From: Adrian Dowd
Sent: 06 August 2019 09:38
To: Nicola Gunn
Subject: FW: Consultation on planning application 3/2019/0588 Holden Clough Nursery, Bolton by Bowland Road, Bolton by Bowland BB7 4PF
Attachments: F- Undulating Lowland Farmland with Wooded Brooks.pdf

From: Lorimer, Elliott [mailto:Elliott.Lorimer@lancashire.gov.uk]
Sent: 05 August 2019 17:56
To: Adrian Dowd
Subject: RE: Consultation on planning application 3/2019/0588 Holden Clough Nursery, Bolton by Bowland Road, Bolton by Bowland BB7 4PF

Please find below my response (on behalf of the Forest of Bowland AONB Partnership) regarding the planning application 3/2019/0588.

Holden Clough Nursery -
Proposed Overflow Car
Park & Growing Area
Scale: 1:500 @ A3

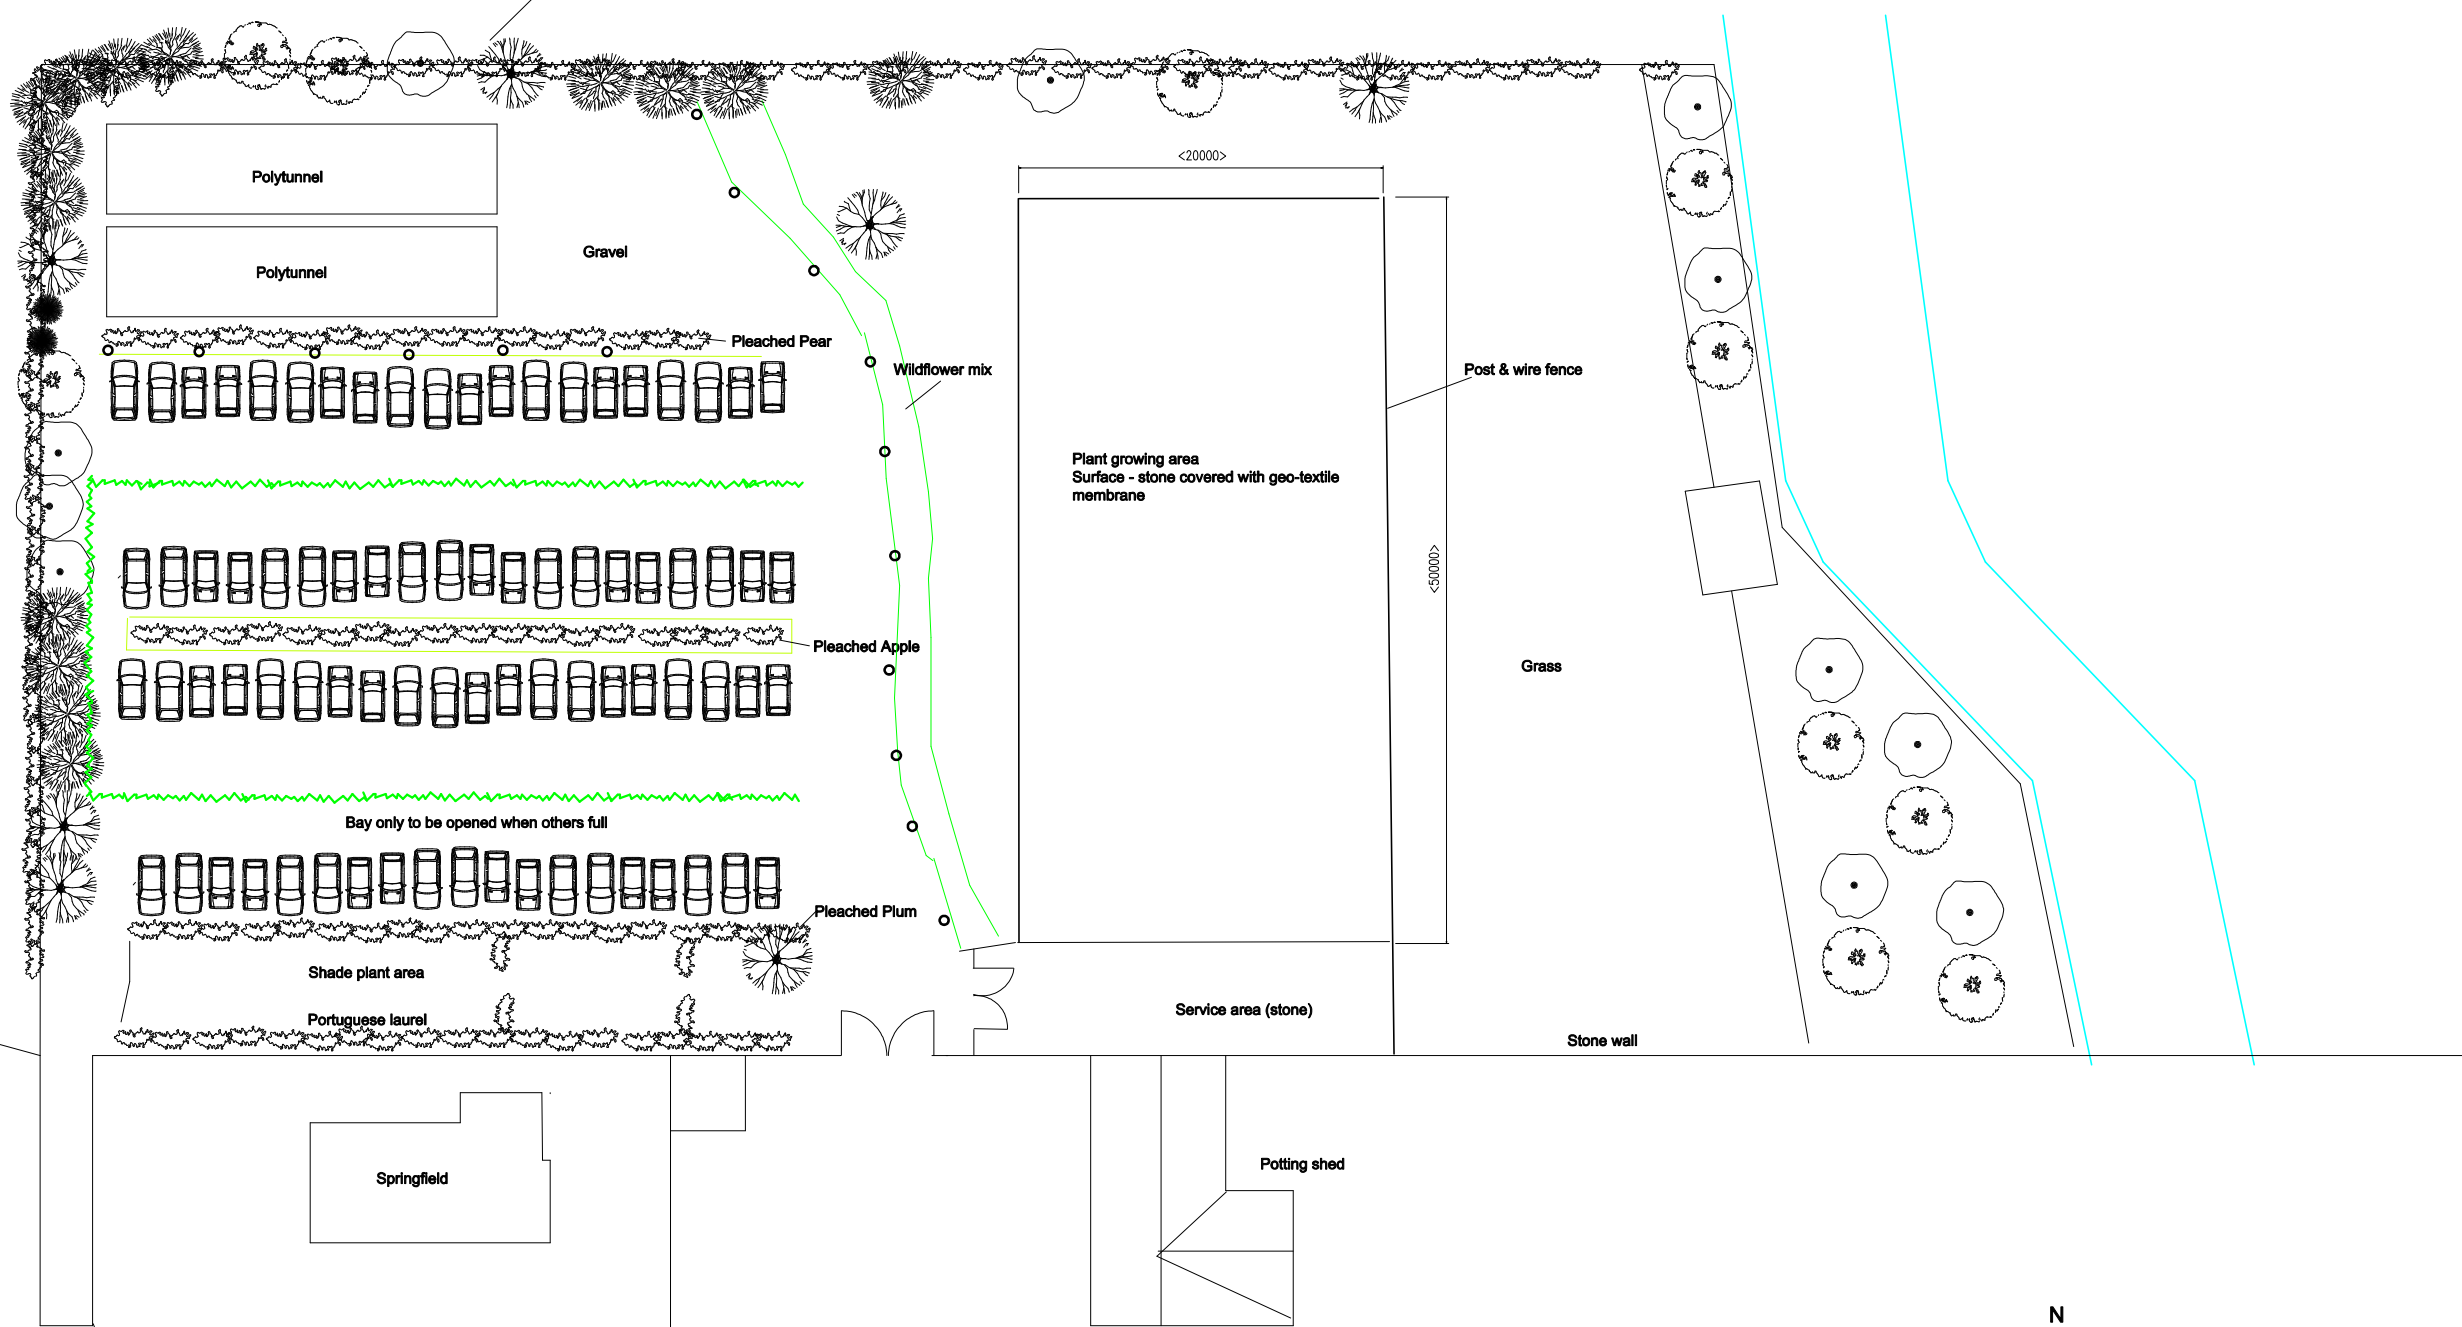
The proposal appears to outline the creation of 79 car spaces within the two acre plot to the north of the existing Holden Clough Nursery site. This will offer an additional 47 spaces for the business, over and above the 62 already provided. The AONB Partnership accepts the principle outlined by the applicant in attempting to address the ongoing parking and traffic issues within the village created by visitors to the Nursery. However, the provision of 79 additional spaces within the western half of the two acre field will have a negative impact on the views of the village setting when approaching from the north along Barret Hill Brow.

In addition, the erection of 2 (no) x 25m long polytunnels in the north-western corner of the site with limited landscaping/screening (a single line of non-native tree species) will again negatively impact on the views of the village setting when approaching from the north along Barret Hill Brow.

In conclusion, the AONB Partnership objects to the application in its current form and design.

- significantly fewer car spaces provided within the two acre plot
- enhance informal planting of native tree and shrub species along the western and northern boundaries of the plot (using space created from the reduced car parking provision) to better screen the polytunnels
